Subject: BR/256/19/PL - 2 Cavendish Road

Proposed First Floor Plan

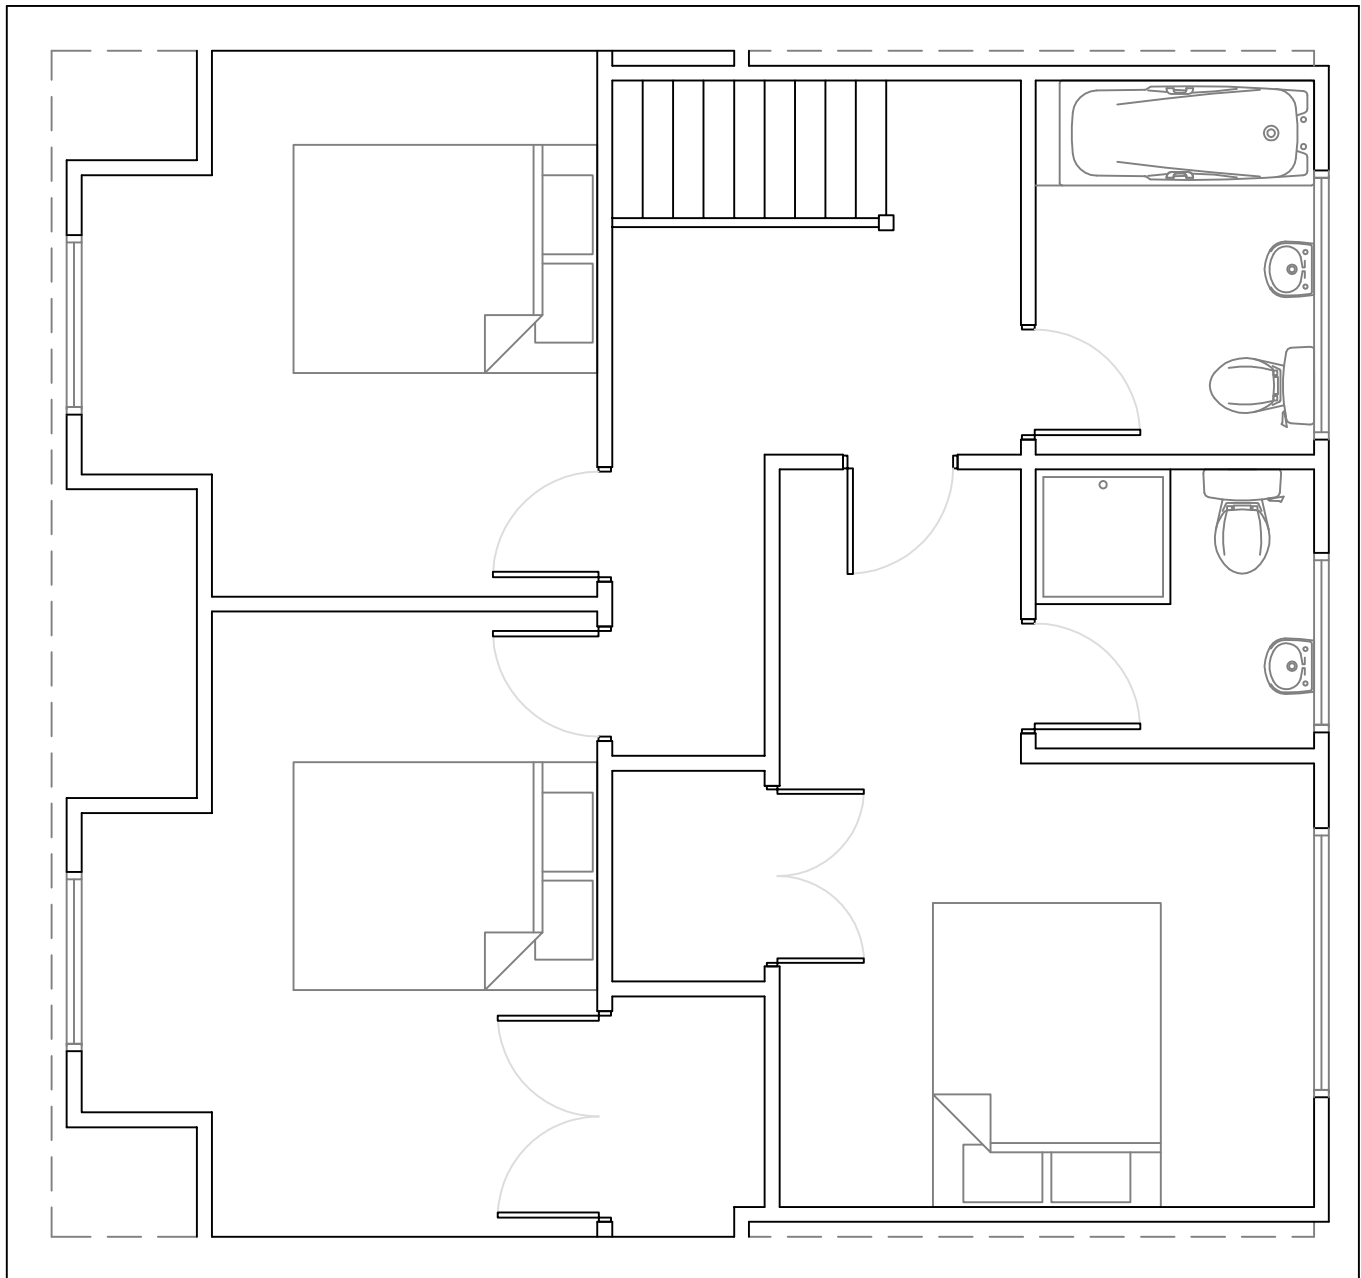
I would like to request that you provide a front to back section for the proposed dwelling conversion so I can assess how much of the first floor space will have a useable floor area (i.e. to check head height). Can you provide this for me.
